Re: AW/246/19/PL – Erection of 1 No. 2 Storey End of Terrace House at land adjacent to 34 Wakefield Way, Bognor Regis PO21 3RS

Reference: - AW/246/19/PL – Erection of 1 No. 2 Storey End of Terrace House

OBJECTION TO THE AFOREMENTIONED APPLICATION

Site Plan

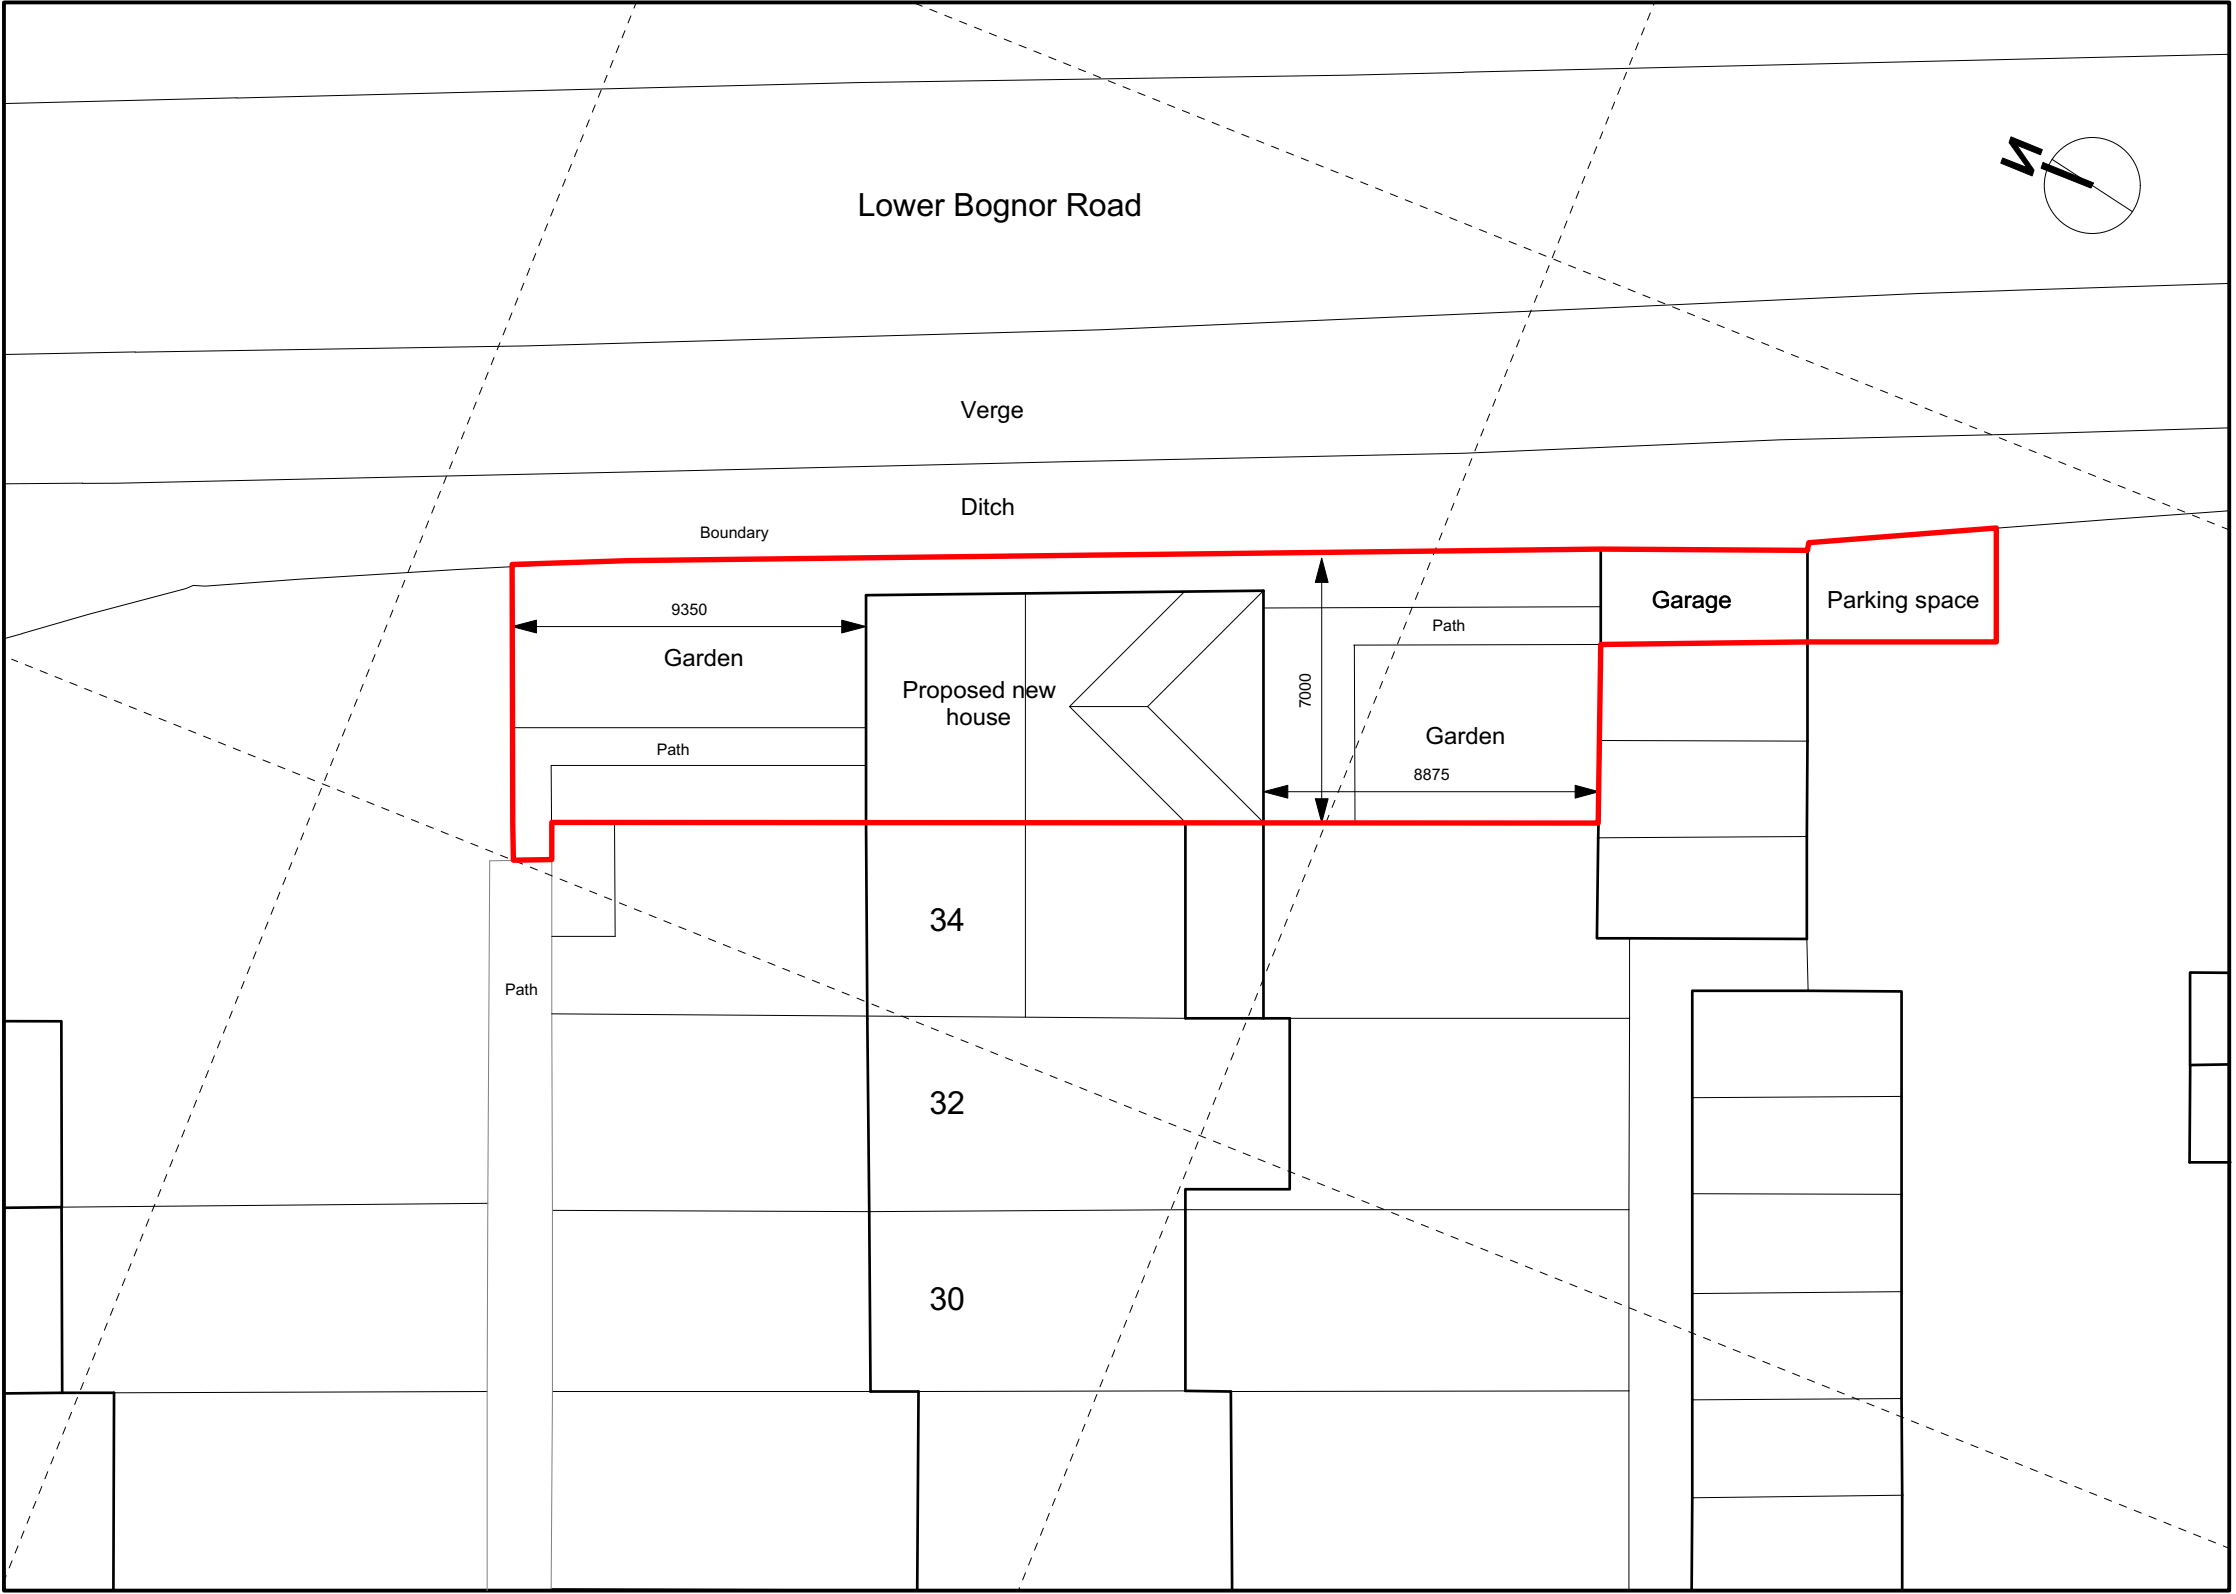
In paragraph 2 of the Design and Access Statement on Page 5 of the self-named document, I quote *"Parking is provided on site, with one garage space and one parking space in front of the garage"*

According to the WSCC Consultation on the planning application the WSCC PDC requires a minimum of three parking spaces to be provided for this size dwelling in this location.

It is our belief that neither of these two proposed spaces constitute a parking provision for the dwelling.

The first of which is a garage situated at the far end of the L/H side of the garage block. This garage is apportioned to No.34 (the existing dwelling) therefore no "additional" space has been created, it has simply been re-assigned from an existing dwelling to the proposed. This conclusion has also been noted within the WSCC Consultation.

There is also a further point to the proposed use of a garage as a parking space within this application. As per the WSCC Consultation, the garage in question is only 2.5m wide and 5.5m long. This is barely big enough for a standard size family vehicle. However, the Design and Access Statement submitted makes note that the garage will also be the "Bin Store" for three wheeled refuse bins along with space for two bicycles. I do not see how a car, three wheelie bins and two bicycles will fit into this garage. The floor space is simply not enough.

Secondly the area of hard standing in front of the garage cannot be assigned to any one property as it does not fall within the ownership boundaries of the existing dwelling.

Therefore, no portion of the forecourt area can be apportioned to any one property as its title belongs to all persons entitled under the same Schedule accompanying their deeds.

In short, no provision of any spaces has been provided for the new dwelling, therefore not meeting the regulatory 3 spaces as set down by the WSCC in their PDC.
